**Application by Highways England for the A47 Blofield to North Burlingham project**  
**The Examining Authority's written questions and requests for information (ExQ2)**  
**Issued on 28 September 2021.**

The following table sets out the Examining Authority's (ExA's) second written questions and requests for information – ExQ2.

DRAWING NUMBER  
HE551490-GTY-HGN-000-DR-CH-30014

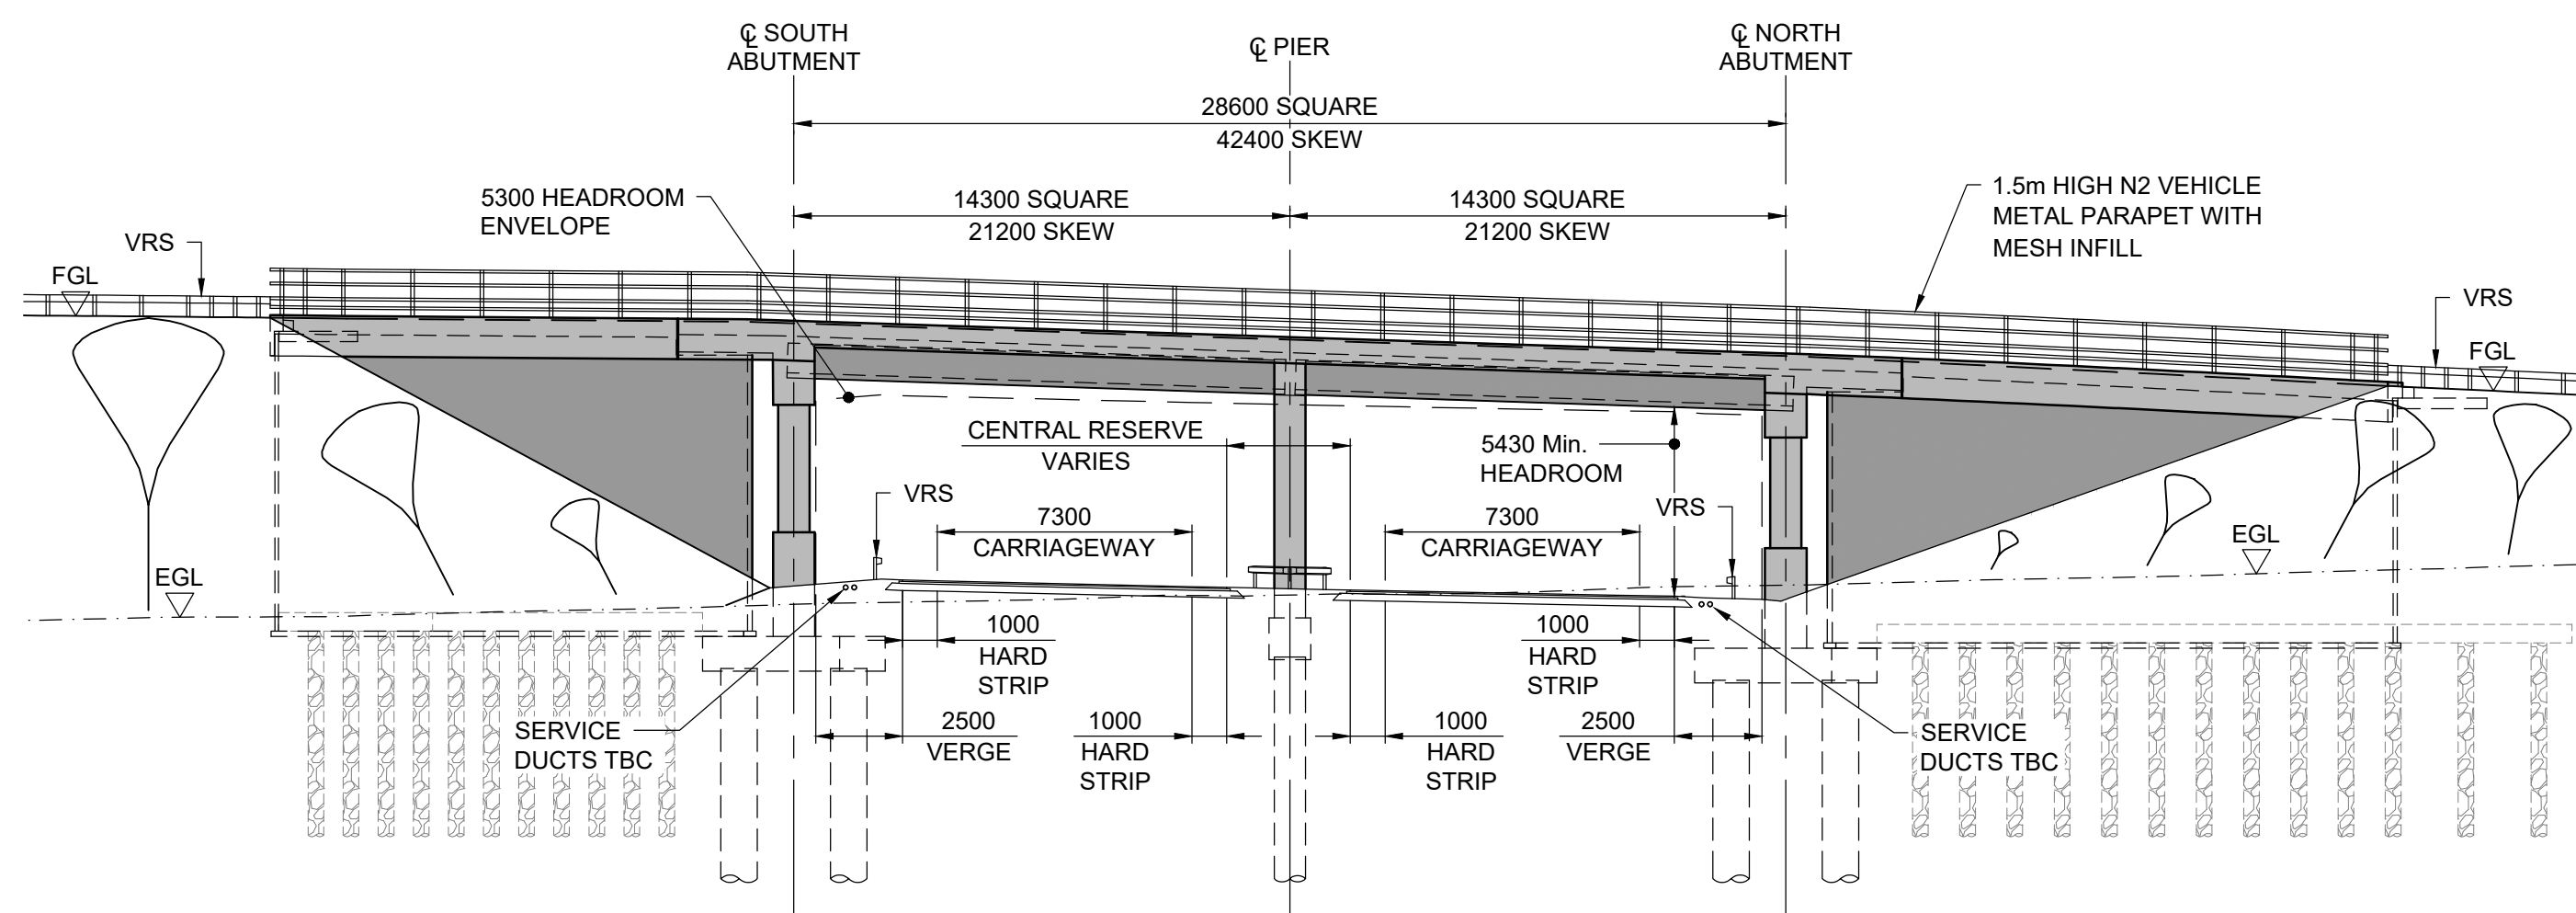
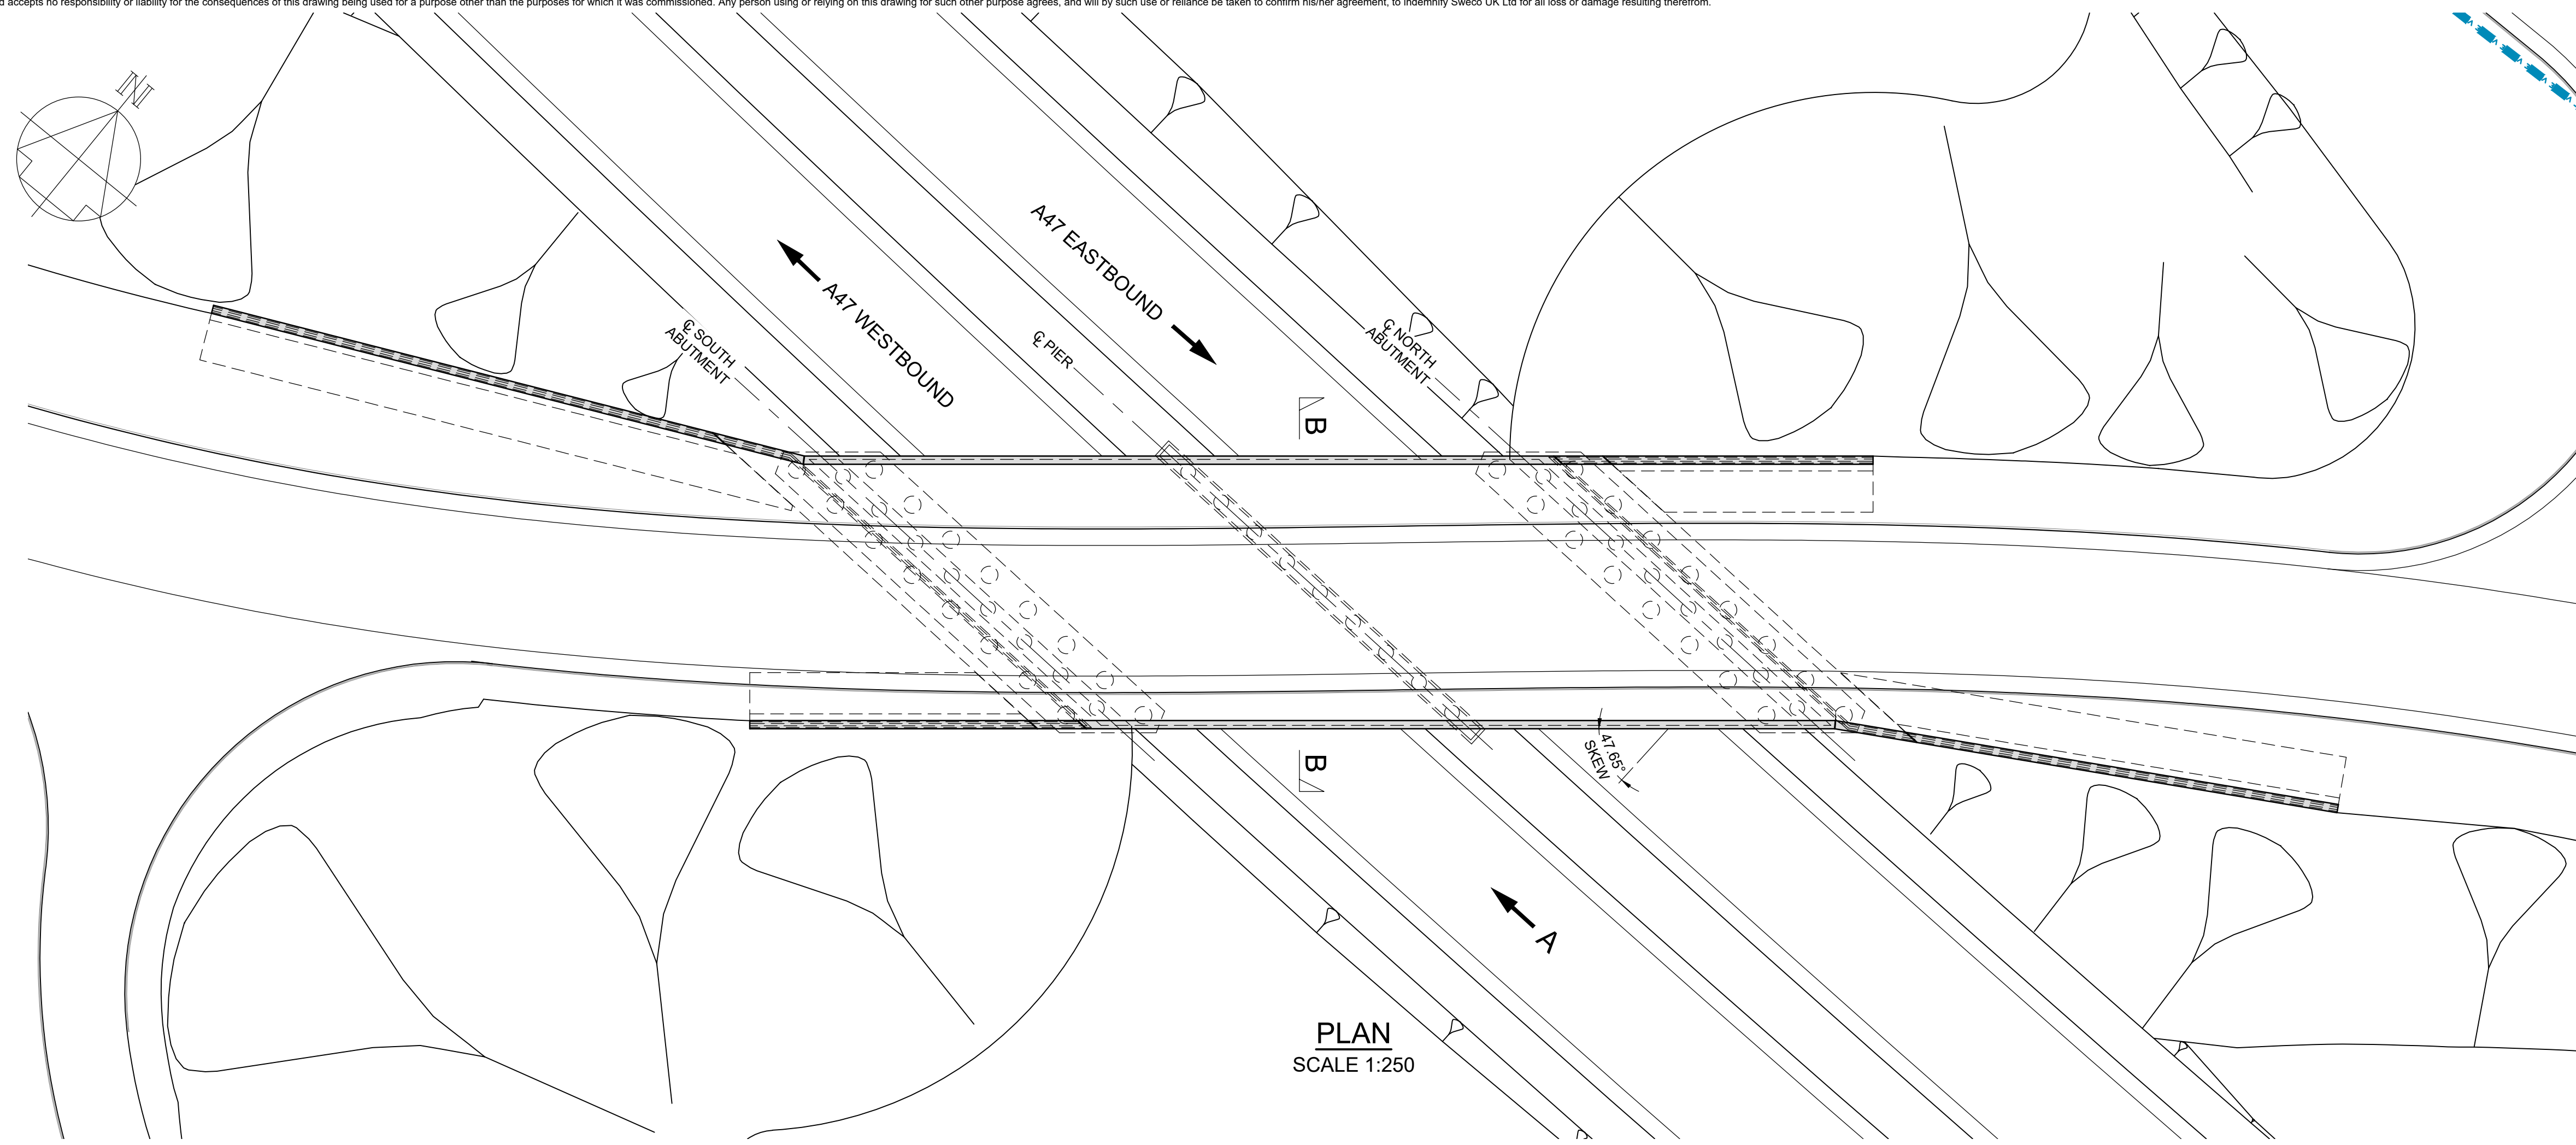
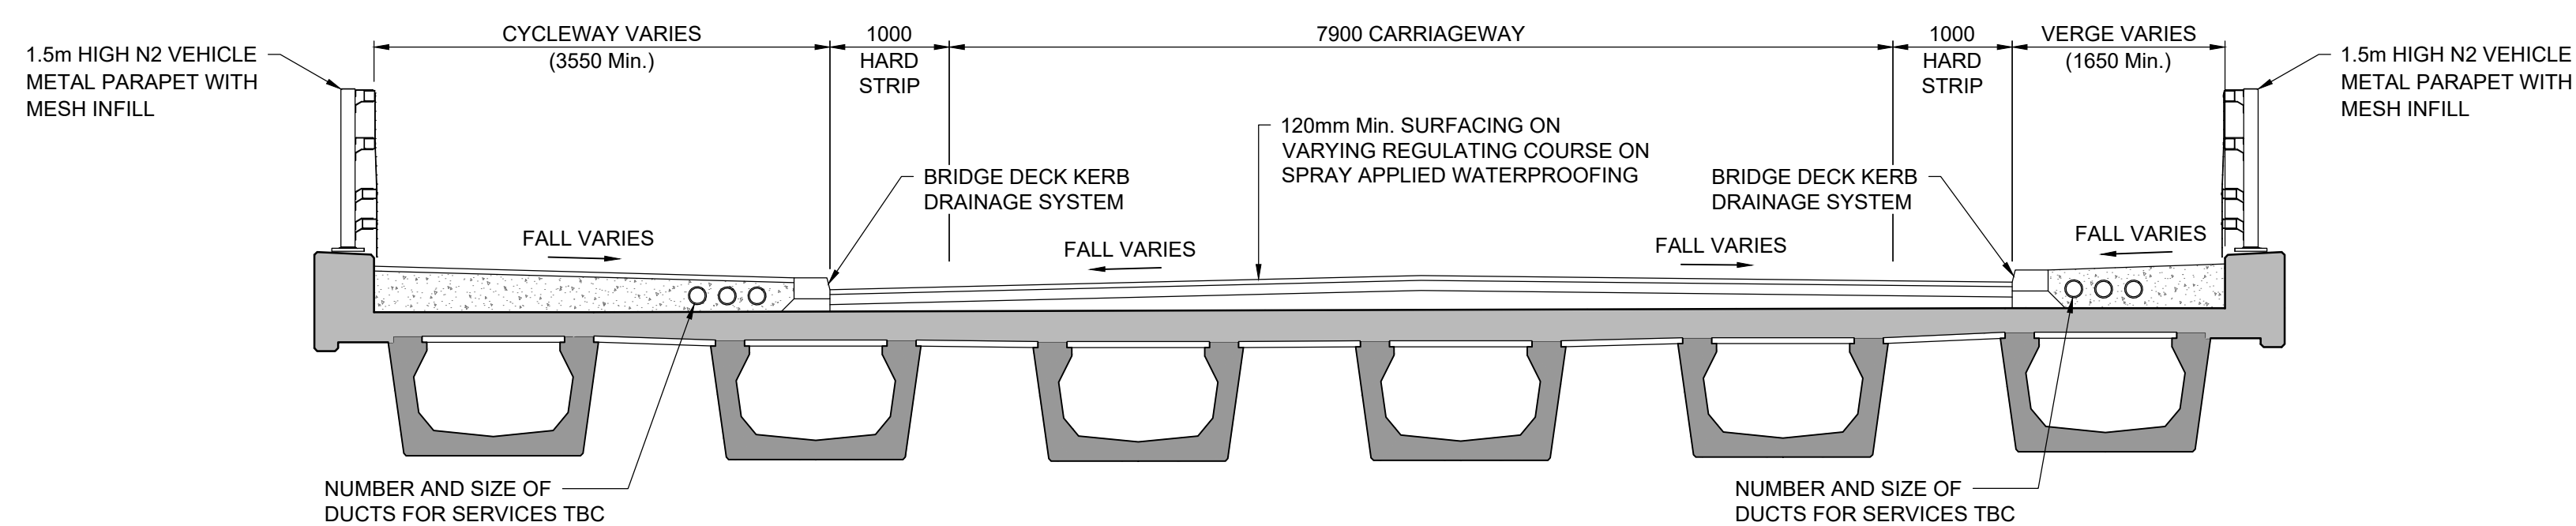
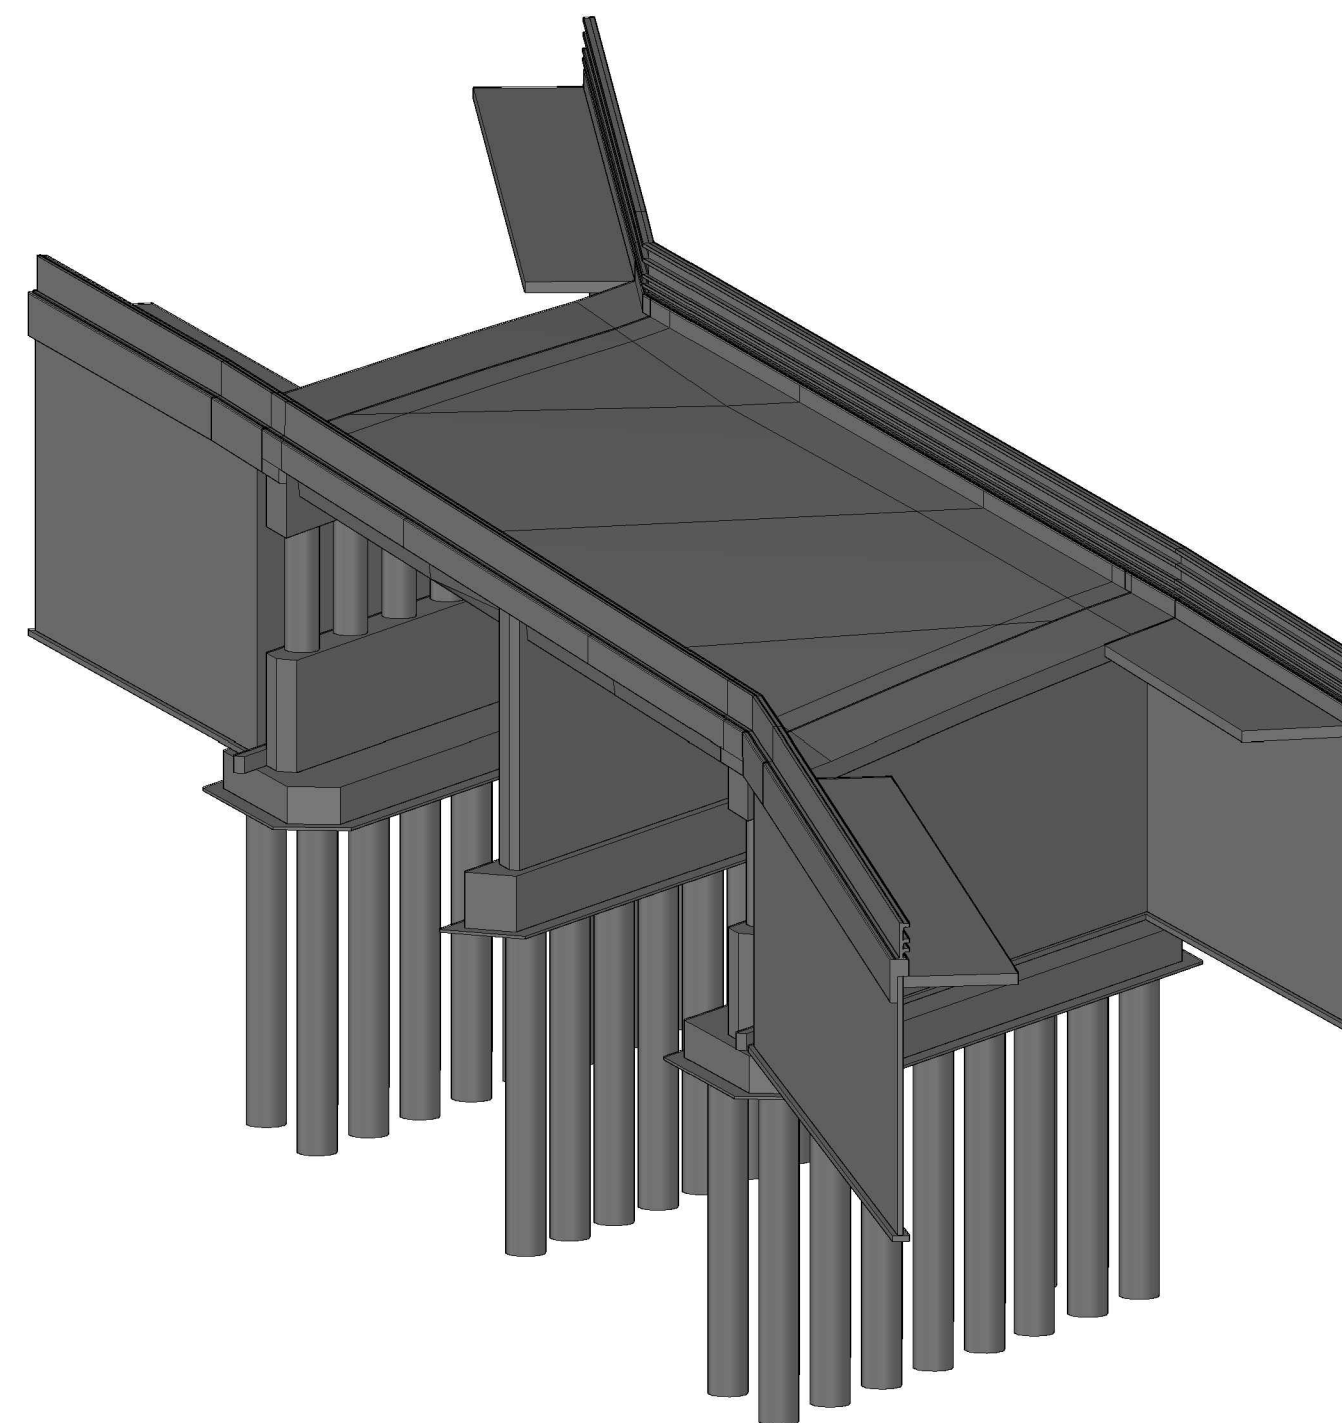
2.14.3	The Applicant	Please: a) explain how shared cycle tracks would be separated from carriageways; and b) clarify whether the separation on overbridges would be provided by the 1000mm width area identified as 'Hard Strip' between the carriageway and the cycleway on the section drawings within the Engineering Drawings and Sections [REP4-005]?
<b>15. Water Environment</b>
